Our ref: Oaklands Solar Farm

Application by Oaklands Farm Solar Limited for an Order Granting Development Consent for Oaklands Farm Solar Park

The National Forest Company

The Illustrative Landscape Strategy Plan

Figure 4.2: Work Area No 1 - Solar array area reference numbers

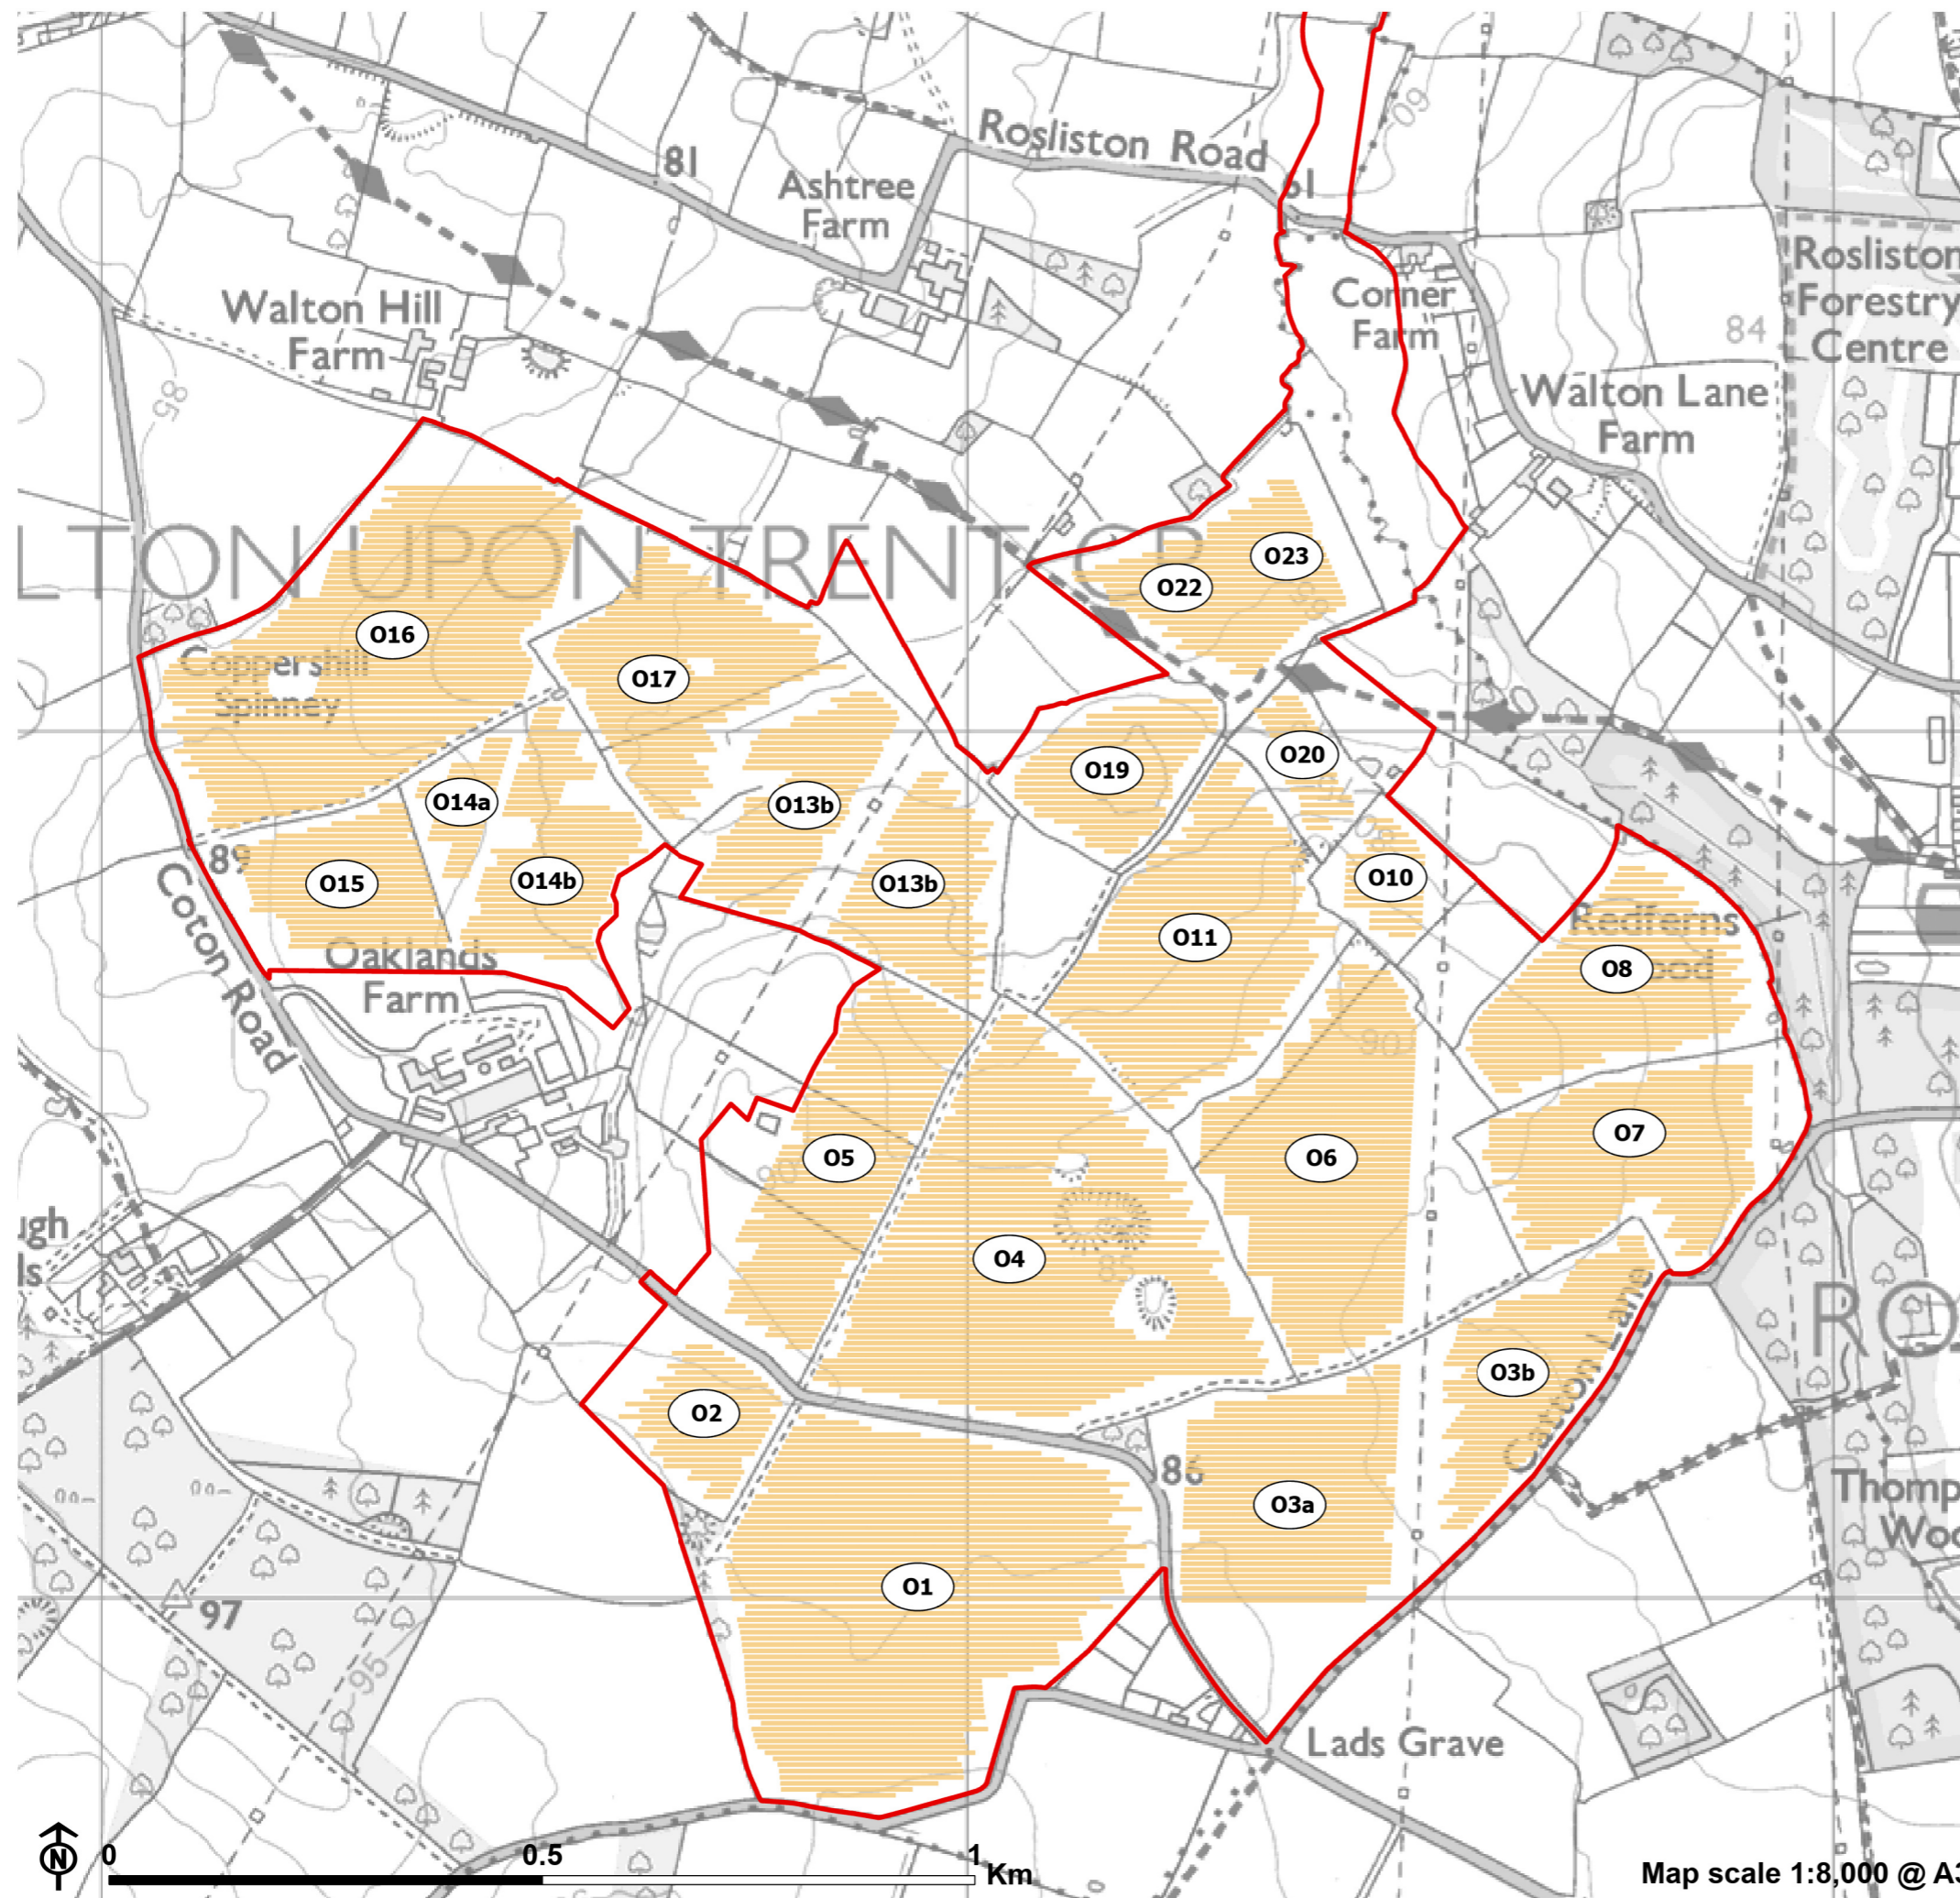
Using the reference numbers on ‘Figure 4.2: Work Area No 1 – Solar array reference numbers’, our priority mapping system has highlighted areas Nos. 07, 08, 022 and 023 as having the highest benefit. Additionally, the area to the north-east of area No. 023 (where the Landscape Strategy details that watercourse trees will be planted along the Pessall Brook) and the field to the north-east of area No. 020 where the National Forest Way passes through also rate highly on the priority mapping system – see map appended to response.
